The Member Secretary,
Chennai Metropolitan
Development Authority,
No.1, Gandhi Irwin Road,
CHENNAI -600 008.

Letter No. B2/18410/2002

Dated: 14.3.2003.

Sub: CMDA - Area Plans Unit - Planning Permission -
Construction of Residential building, Stilt
Floor parking + 4Floor (with 8 dwelling units)
at Plot Nos.178 & 179 Chinthamani Vinayagar
Koil Street, Rama Krishna Nagar, Valasaravakkam
Chennai, S.No.116/75 (as per patta) Old S.No.
116/2part of Valasaravakkam Village - Remittance
of Development Charge & Other charges - Revised
order

PLAN (R.C.C COLUMN DETAILS)
AS PER STRUCTURAL DESIGN

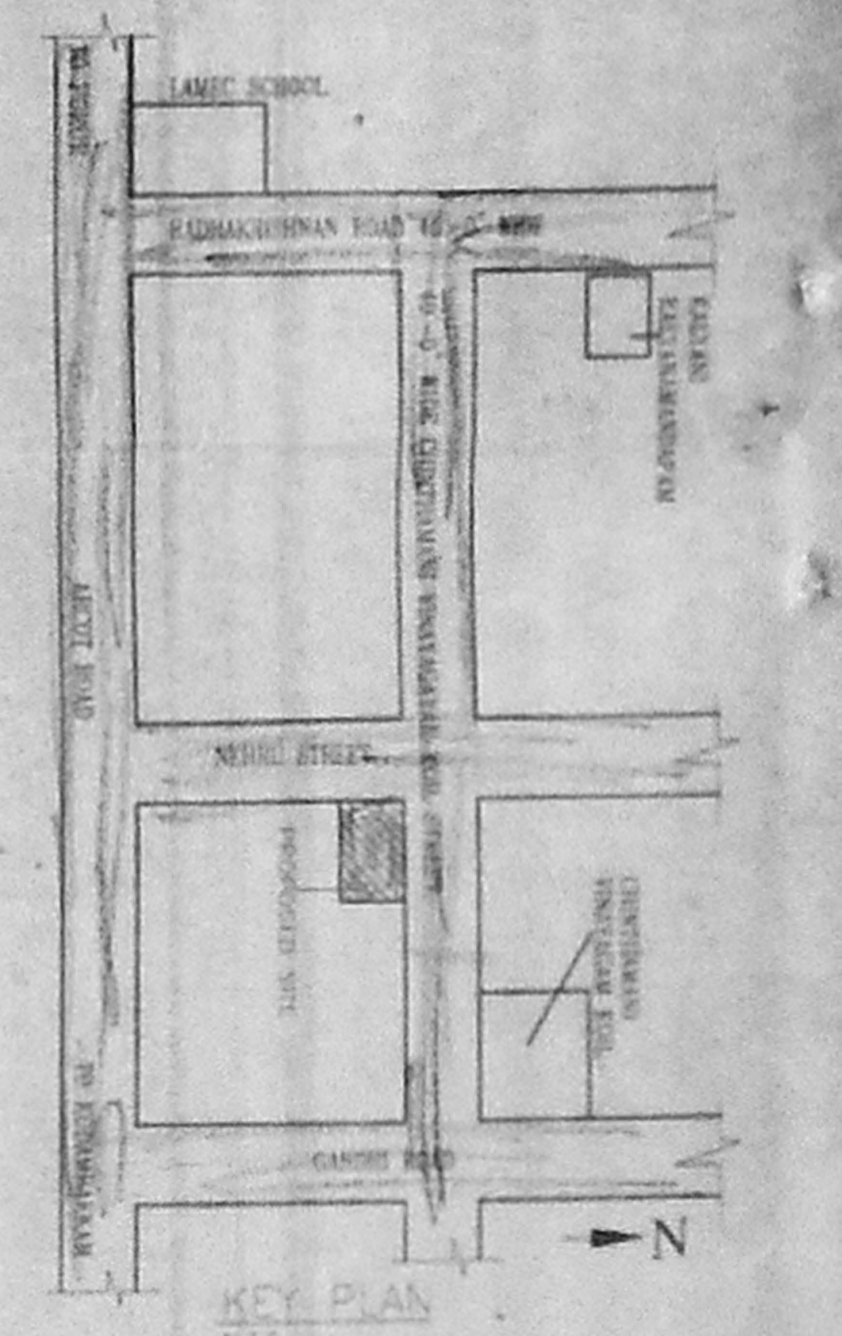
5. You are also requested to furnish revised Plan showing the correct positioning of columns.
